To: FILE
From: Nell Donaldson
Subject: Application ID: 2013-179
Date: 9/19/2013

To: Nell Donaldson
Barbara Barhydt
From: David Margolis-Pineo
Re: Review Comments – Bayhouse II – 40 Hancock Street

The Department of Public Services has the following preliminary review comments for the above mentioned project.

**BOUNDARY & TOPOGRAPHIC SURVEY**  
 OF:  
 SEAPORT LOFTS  
 NEWBURY / HANCOCK STREET  
 PORTLAND, MAINE  
 FOR:  
 113 NEWBURY STREET, LLC  
 35 FAY STREET, SUITE 07B  
 BOSTON, MA 02118-4920

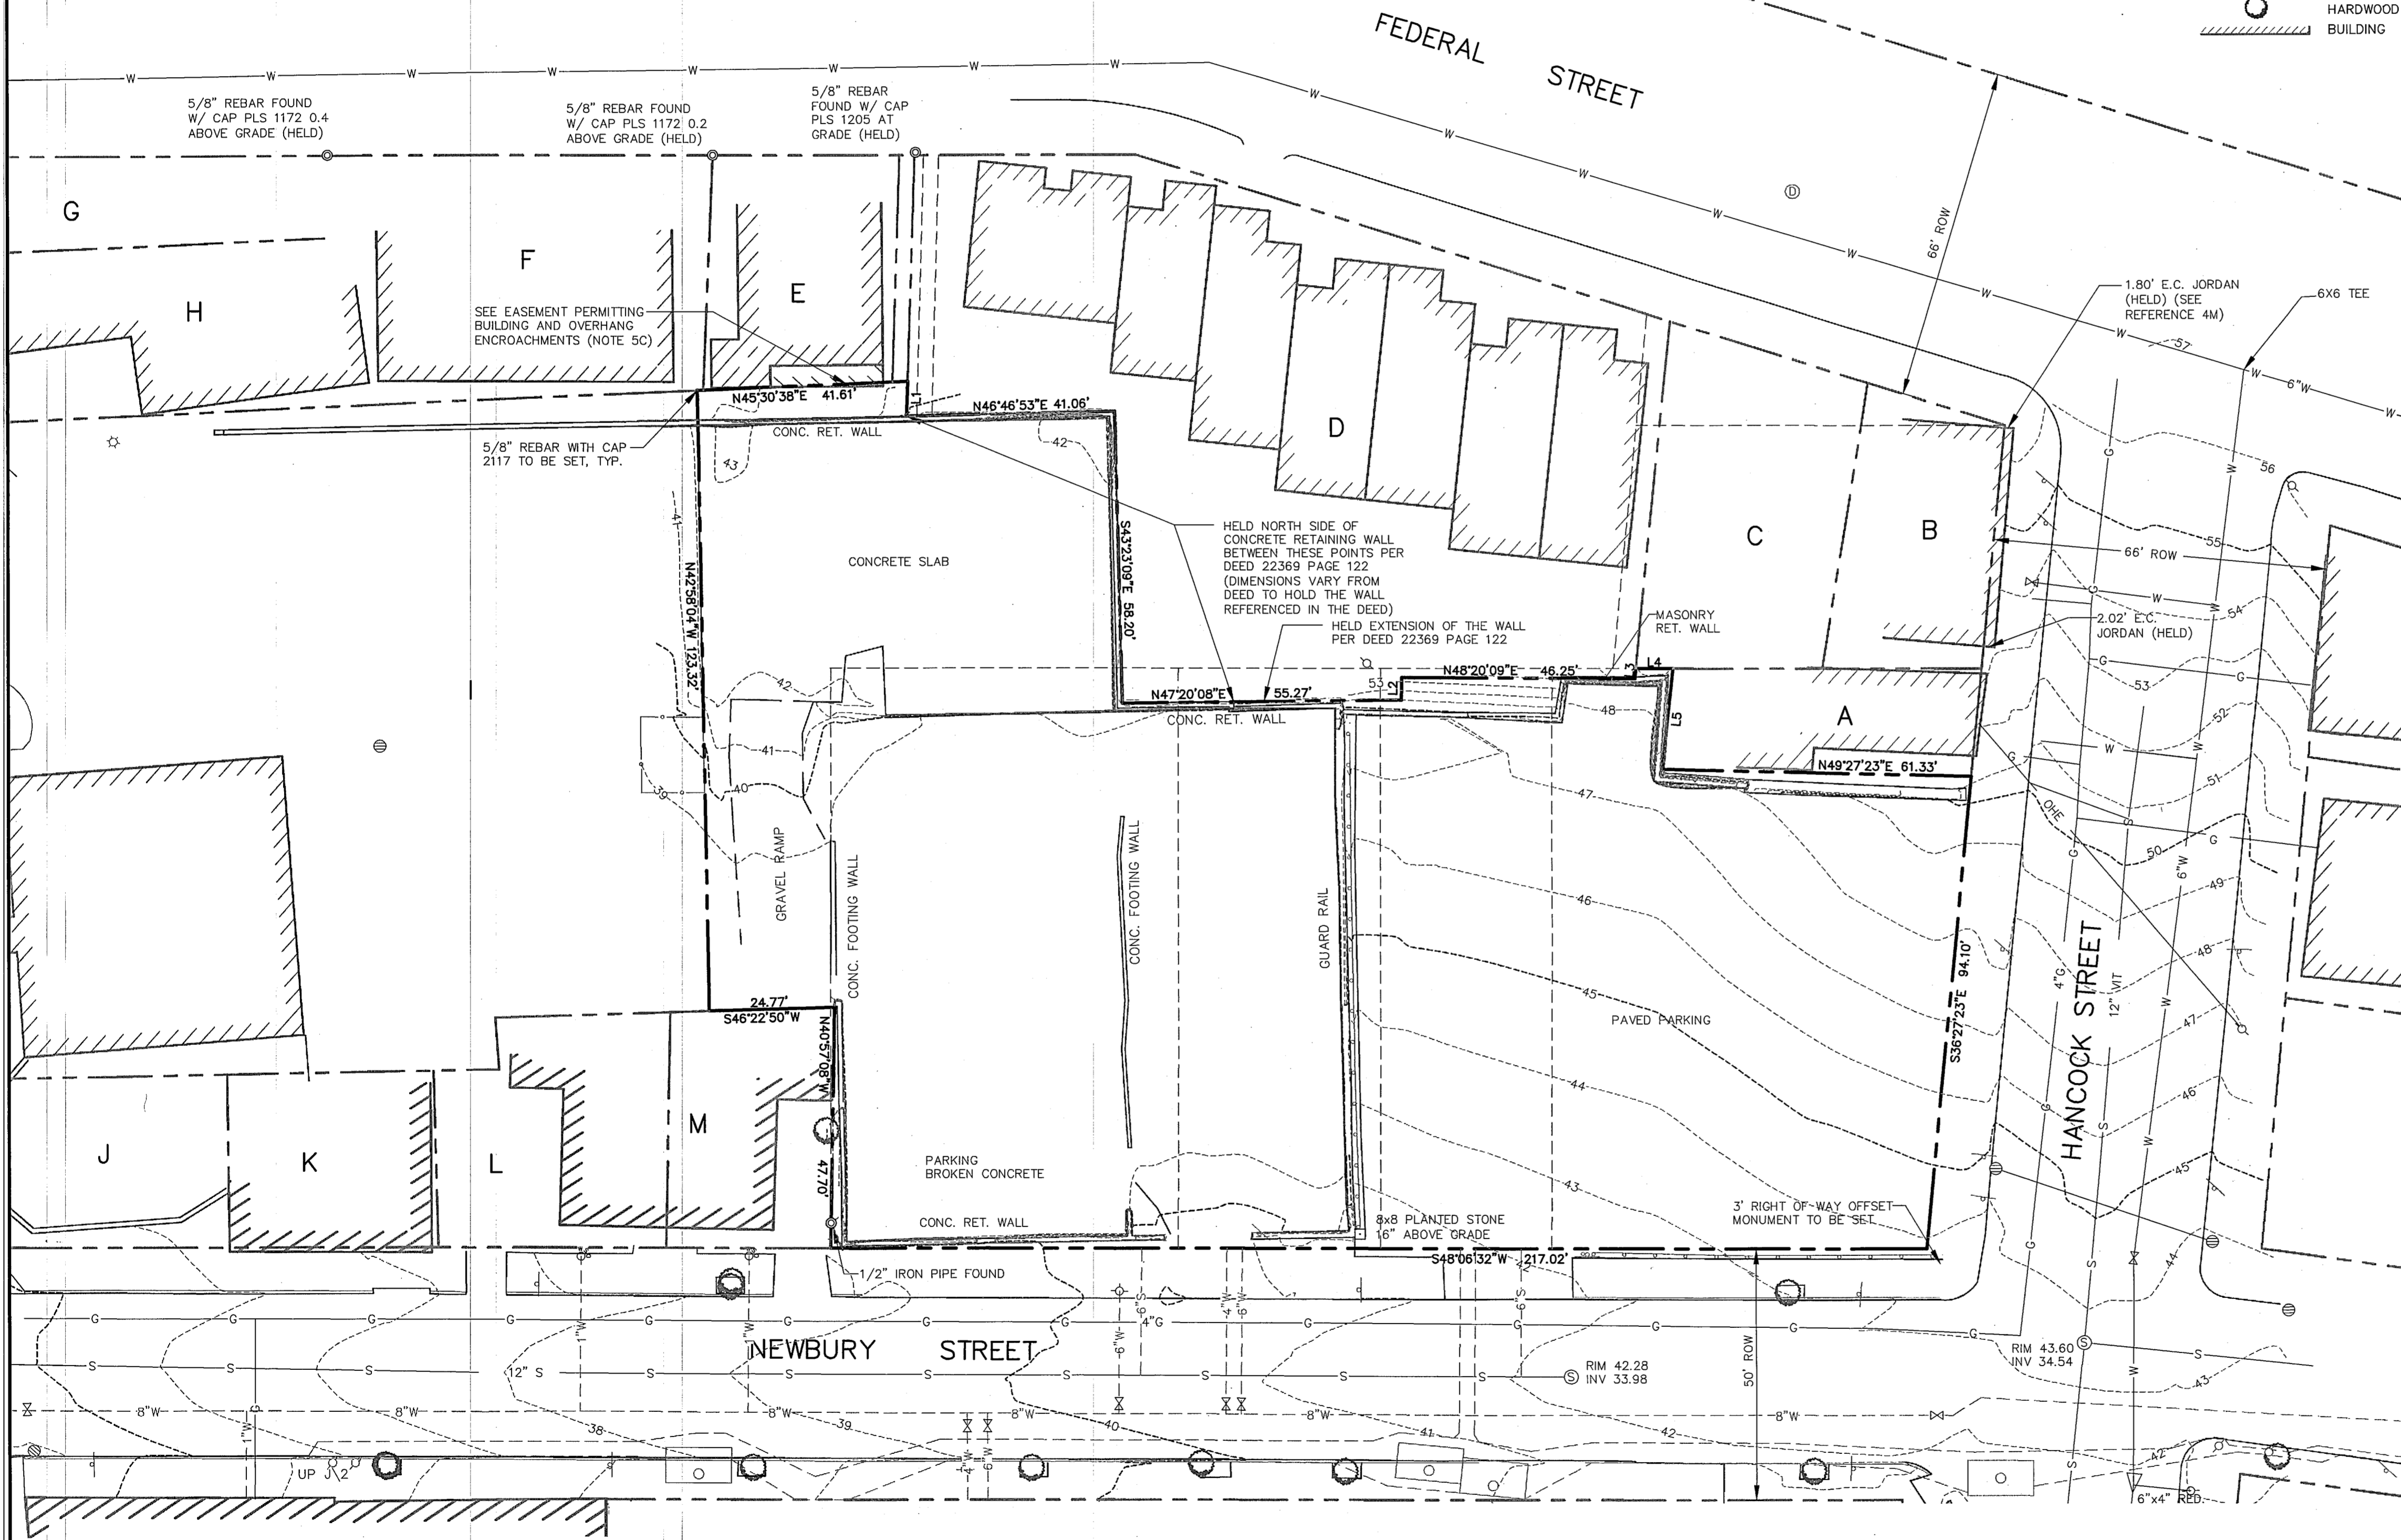
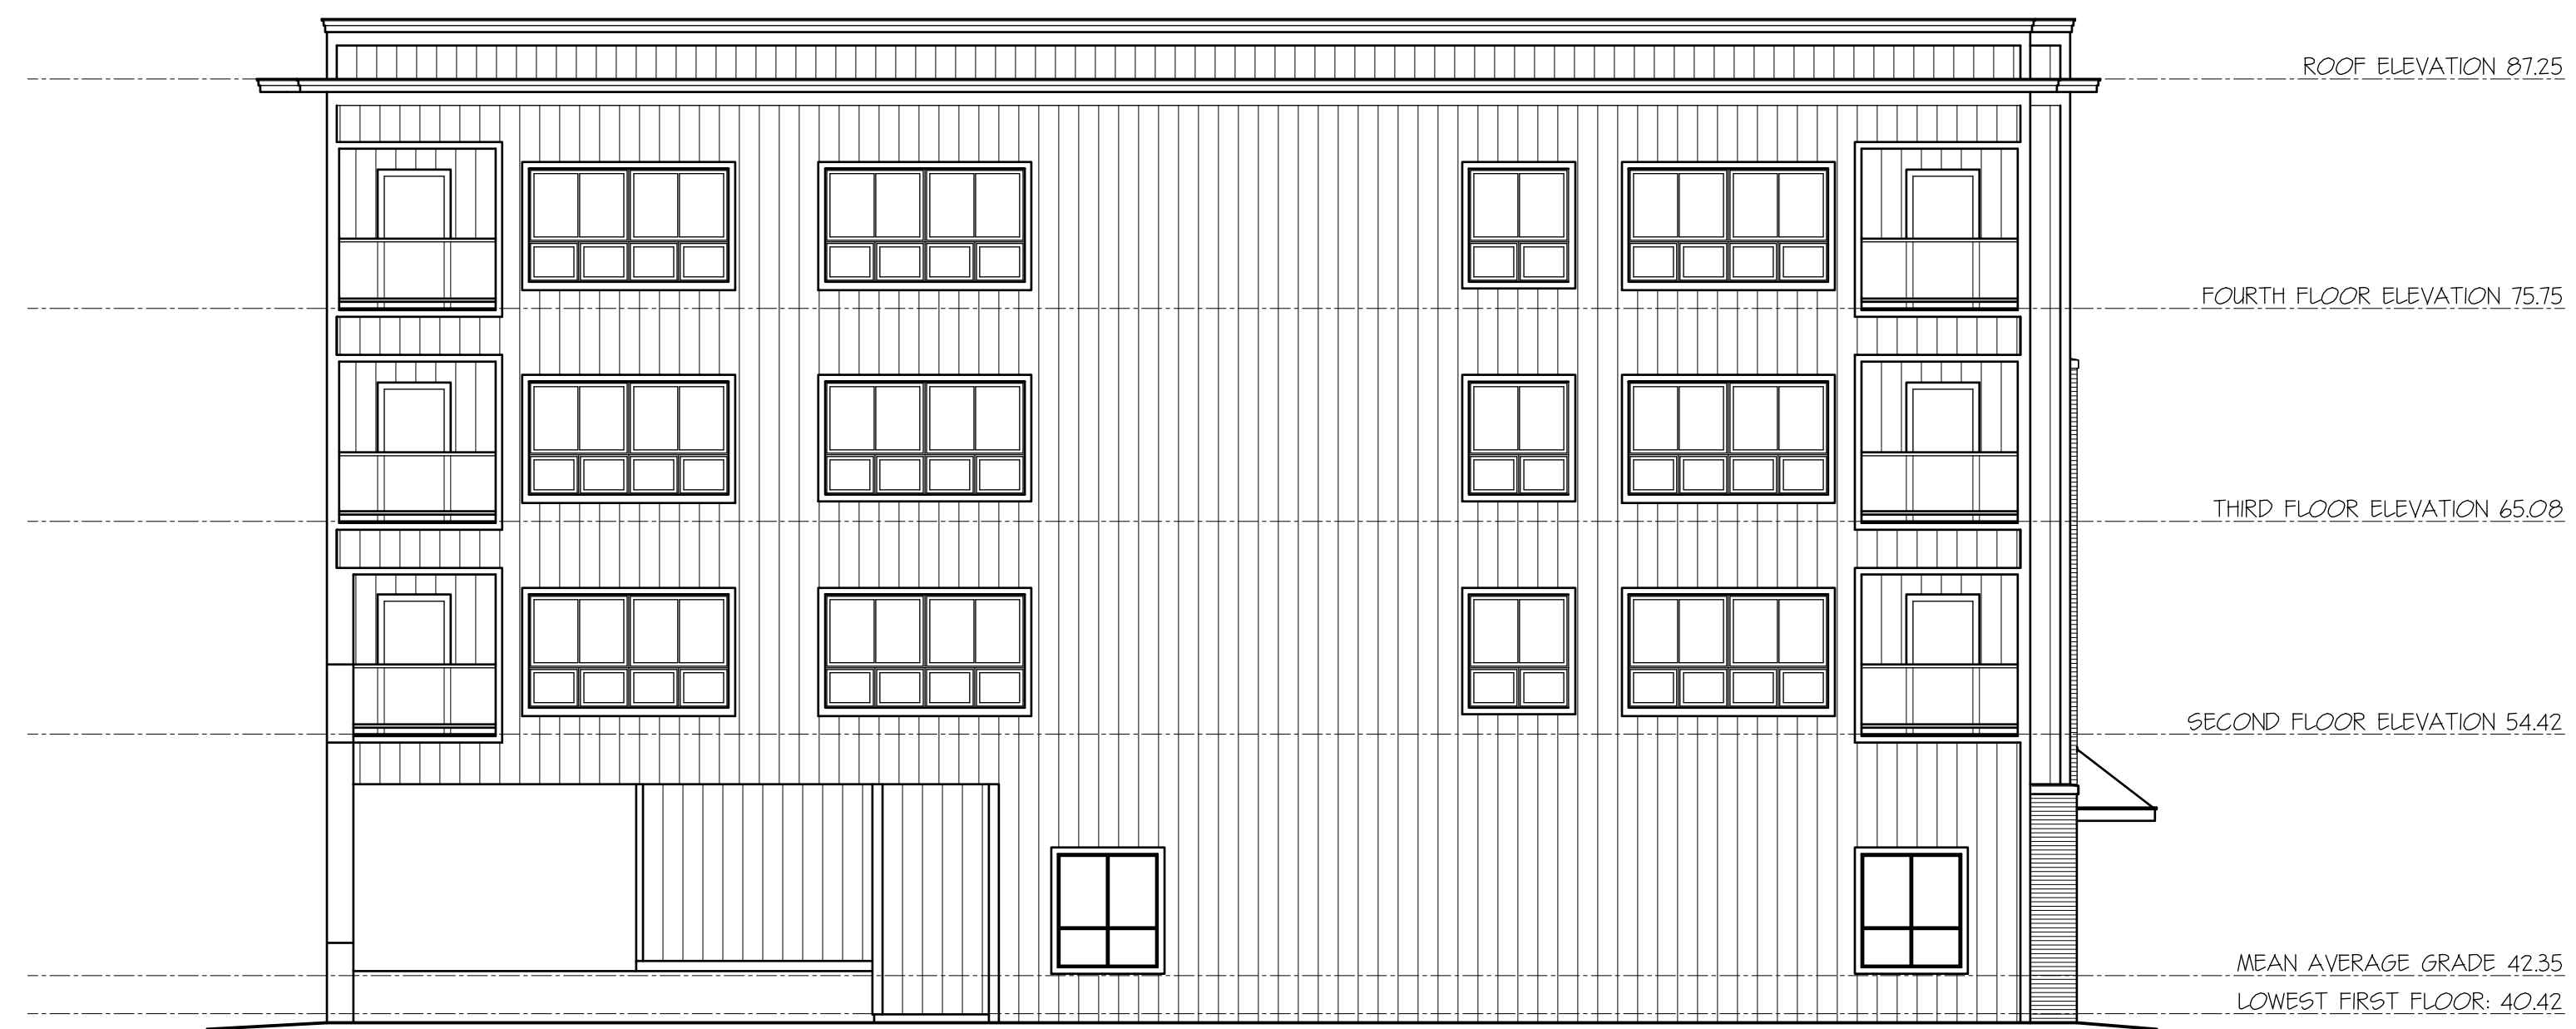
13. The survey plan requires a profession's stamp and currently the plan is not acceptable. Note 8 states, "Boundary information shown hereon is approximate until the research has been updated." When the property survey is complete, please re-submit. Also.....
Issue resolved.

14. Please show the three-foot offset monument at the westerly corner of Newbury St and Hancock St.
Still needs to be complete.
Issue resolved.

15. Please show State Plane Coordinates for the three-foot offset monument at the westerly corner of Newbury St and Hancock St and the three-foot offset monument at the southerly corner of Middle St and Hancock St
Not complete.
Issue addressed.

16. Need to show property corners to set.
Not complete
Issue addressed.

17. Northwesterly boundary line along the Federal Street abutting properties has changed since the overall Phase II survey plan dated 7/13/2013. The concrete retaining wall was apparently entirely on the Phase II property on the 7/13/2013 plan, and a section is now on abutting land. Why the change?
Issue addressed

**PROFILE: HANCOCK STREET**  
 STA. 3+11.7 TO STA. 6+75  
 SCALE: 1"=30' HORIZ.  
 1"=3' VERT.

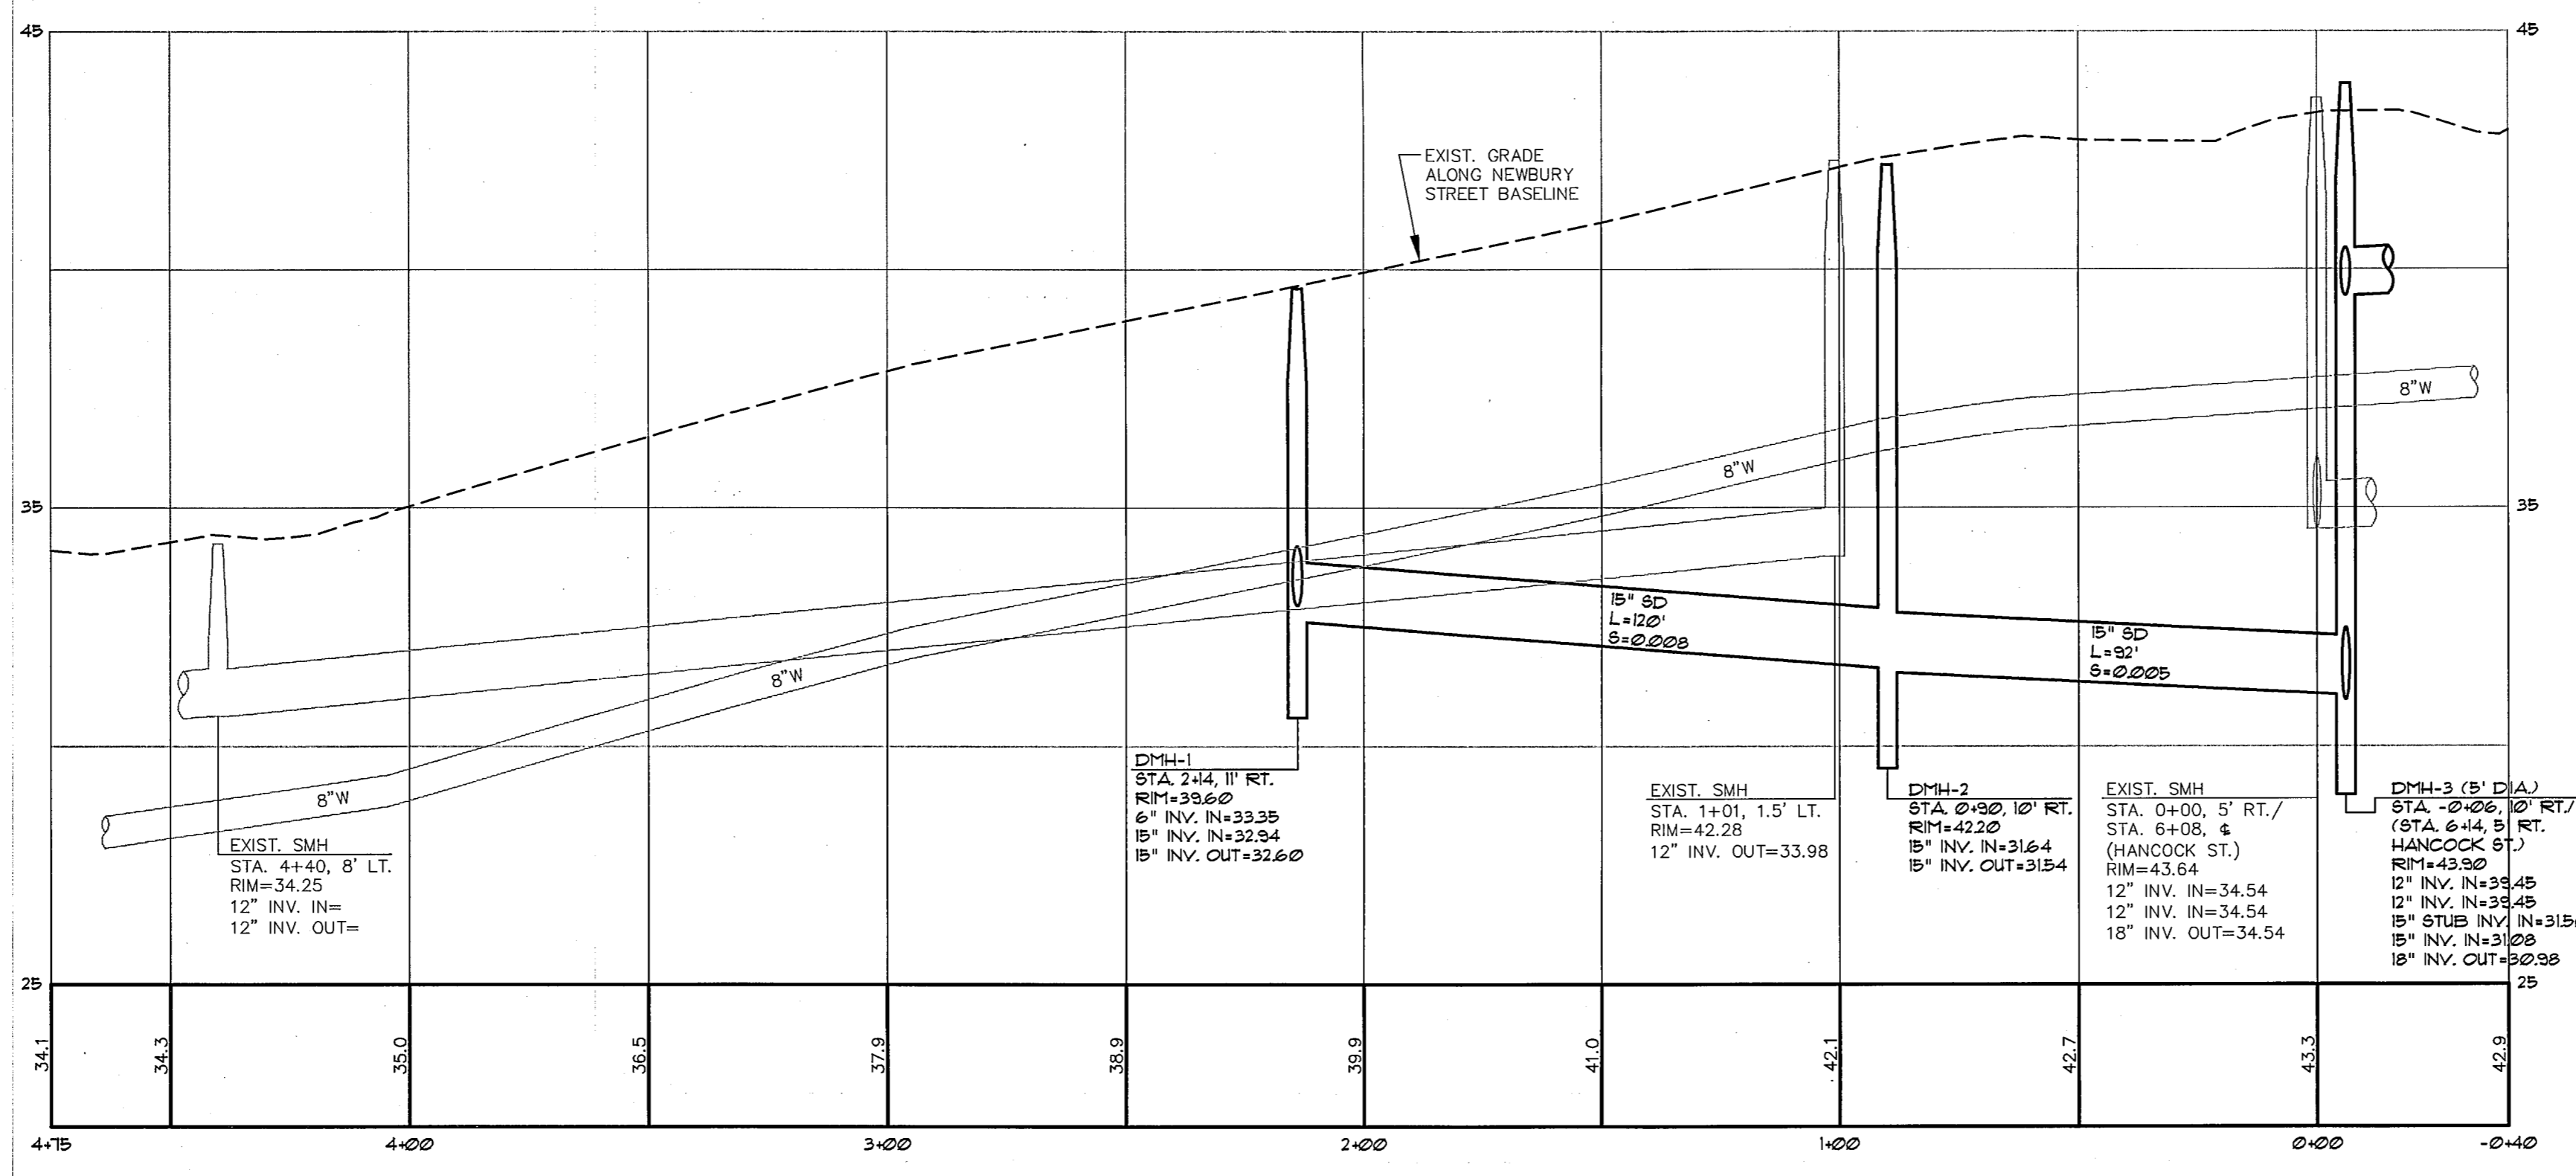
4. Due to the close proximity of the proposed stormwater drainage system to the existing waterlines, it is requested that these plans be shared with the Portland Water District for review. Also it is requested that a profile of the proposed stormwater system be submitted for review and approval.
I am not aware that either item has been addressed.
Applicant states plans have been sent to the PWD for review.
Issue addressed.
